From: Martin Hill <Martin.Hill@arun.gov.uk>
Sent: 04 October 2020 21:16
To: Planning.Responses <Planning.Responses@arun.gov.uk>
Subject: RE: Planning Consultation on: LU/241/20/CLE

Comments from Private Sector Housing:

Application No: LU/241/20/CLE
Registered: 22nd September 2020
Site Address: 6 Selborne Place Selborne Road Littlehampton BN17 5NH
Grid Reference: 503276 101647
Description of Works: Lawful development certificate for existing use of building as a large House in Multiple Occupation (Sui Generis).

Proposed Ground Floor Plan 1:50

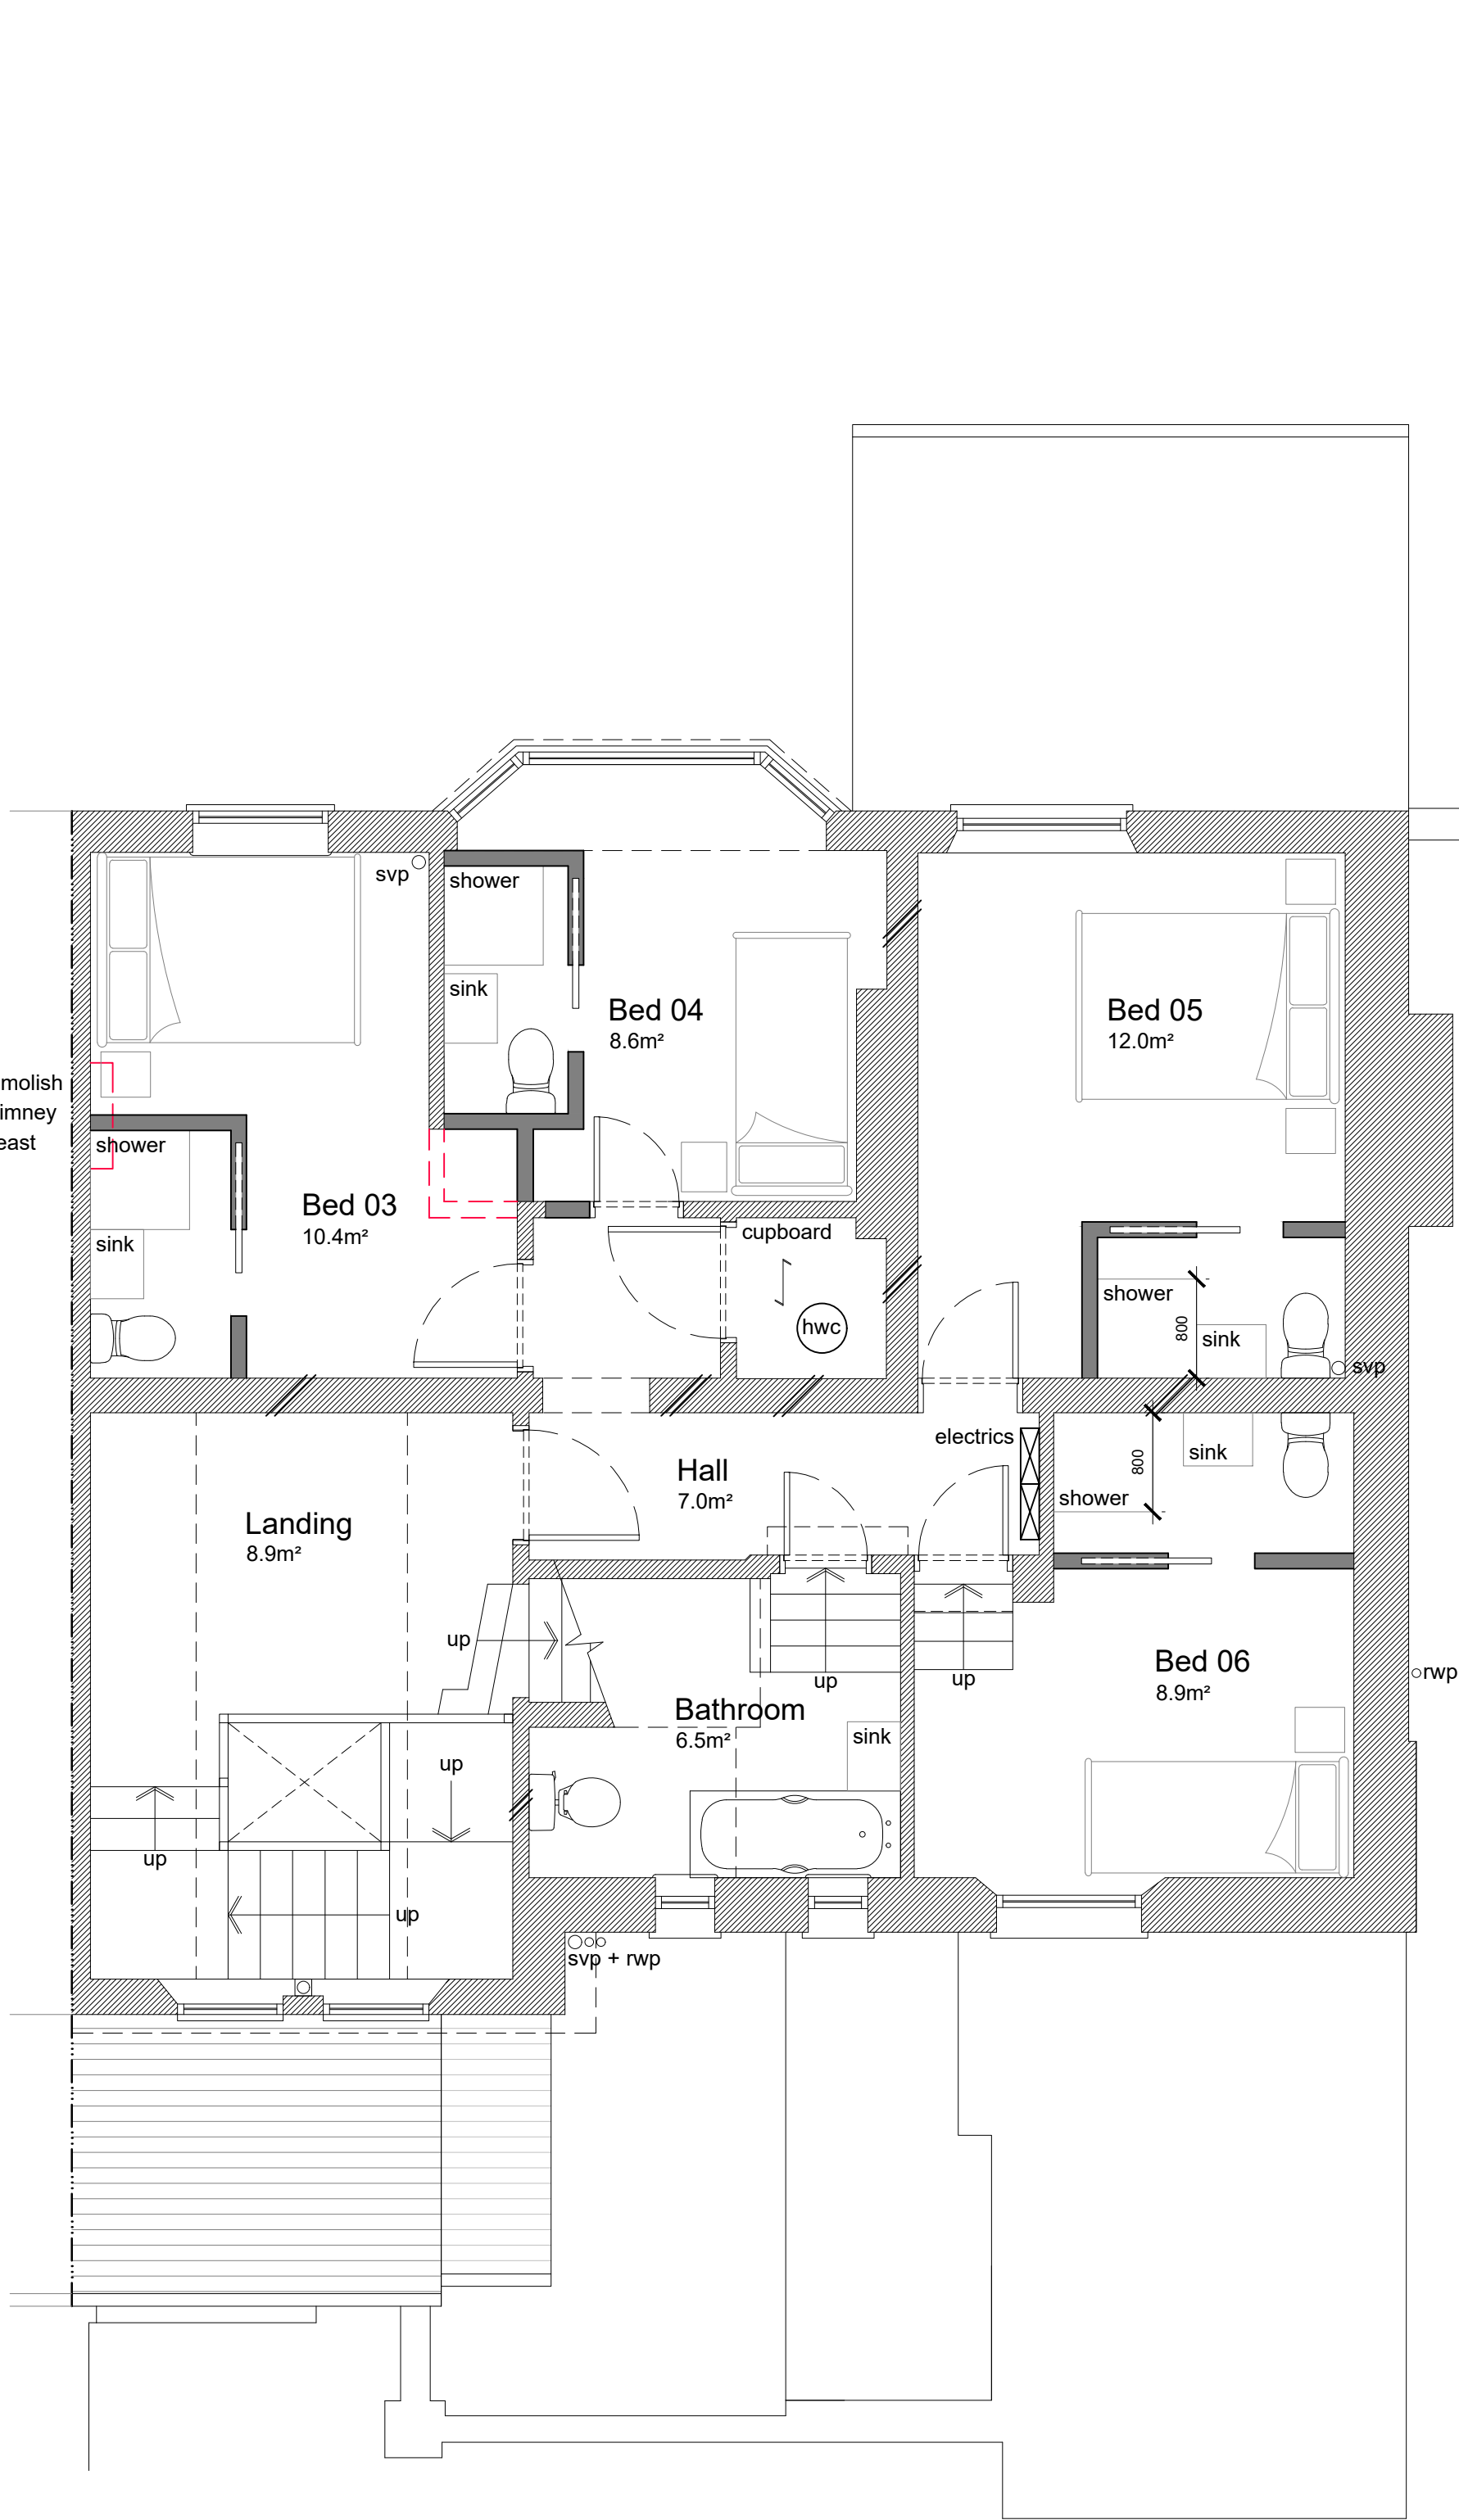
- A wash hand basin must be installed within the same compartment as the WC within the ground floor Cloak Room compartment..
- The ground floor Cloak Room door appears to conflict with the ground floor entrance lobby door. Consideration should be given to the removal of the internal lobby door. Alternatively, careful consideration of changing the opening direction of the Cloak Room door, but this presents a risk of falls on stairs if the door were to open inwards and may require additional safety facilities, such as hand rails to be acceptable; the applicant should seek the advice of Arun District Council's Building Control department if considering this.

- There must be a minimum 30 minute fire resistance between the basement area and the floors above. This must include a 30 minute fire door to FD30S standard at the entrance to the basement at kitchen level.
- All bedrooms and risk rooms must be fitted with FD30S fire doors.
- Travel distance should not be excessive.
- Any under-stairs areas must be protected with 30 minutes fire-resistance (under-drawn) which must include the underside of the stairs, spandrel walls and doors.
